28 March 2022

Hornsea Project Four Offshore Wind Farm Examining Authority Round One Questions and Responses

**Figure 7.1 Illustrative SAR access lanes and HRA**

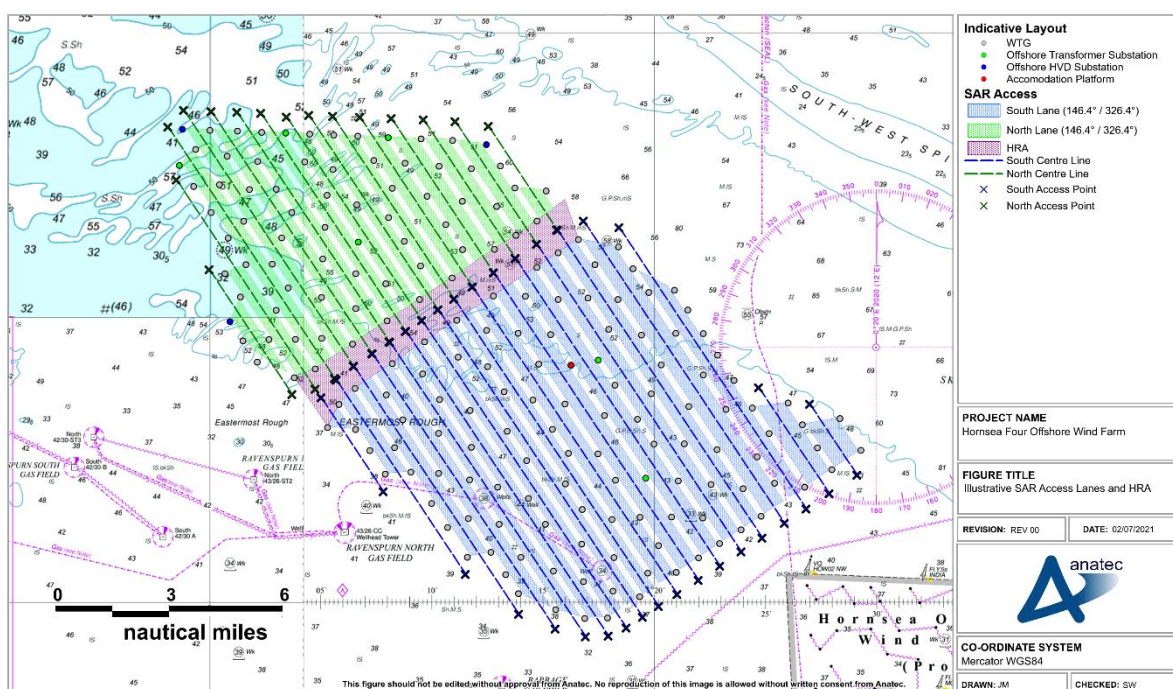
NAR.1.7	Maritime and Coastguard Agency (MCA) and Trinity House (TH) and UK Chamber of	<p>Navigational risk assessment for gap between arrays</p> <p>Please confirm whether you are satisfied with:</p> <ul style="list-style-type: none"> • the navigational risk assessment conclusions for shipping transit through the proposed gap between 	<p>The Chamber has reviewed the NRA and is satisfied with the navigational risk assessment conclusions for shipping transiting through the proposed gap between Hornsea Four and Hornsea Two.</p> <p>The Chamber views the safety measures as acceptable but would</p>

Shipping	<p>Hornsea 4 and Hornsea 2 with a 'pinch-point' of 2.2nm width (centre to centre of proposed WTGs); and</p> <ul style="list-style-type: none"> the appropriateness and sufficiency of additional safety measures proposed in the ES [APP082] during construction or maintenance of the proposed OWF when the width could be reduced by the presence of construction vessels and safety zones and noting TH's concern that the given width does not account for WTG blade overfly. <p>If you are not satisfied with this explain why and what actions you would wish to see to address your concerns.</p>	see the commitment as stated in the response to the prior question as preferable.
NAR.1.8	Maritime and Coastguard Agency (MCA) and Trinity House (TH) and UK Chamber of Shipping	<p>Traffic Monitoring</p> <p>Are you satisfied with the Applicant's response and commitment to Traffic Monitoring "for the duration of the construction period" [APP-133, page 355]? If not, why not?</p>	<p>The Chamber believes AIS traffic monitoring is highly important in ensuring the risk mitigations proposed by the applicant result in risk reduction to ALARP as the modelling put forward suggests. As such ending Traffic Monitoring immediately following the end of construction will not enable this to occur and should be reconsidered.</p> <p>The Chamber notes however that within (APP-083) A5.7.1 NRA Part 2 paragraph 628, states:</p> <p><i>"Whilst no Radar monitoring of vessel movements has been proposed for the Hornsea Four array area, AIS monitoring will be available from a vessel (during construction) and site location (during operation and maintenance) to record the movements of vessels around the Hornsea Four array area."</i></p> <p>The Chamber understands this to mean that site location AIS recording will be undertaken during operation and maintenance phases. The Chamber supports this statement to undertake site monitoring during these phases and hence is unclear as to the</p>

<p>response given to the MCA on page 355 of APP-133 for monitoring only during construction.</p> <p>In the Chamber's view, the vessels within its membership all exceed the tonnage to which AIS transponders are mandatory. Accordingly, radar monitoring is not as crucial and post consent monitoring should focus on AIS.</p>
--	--	--	---
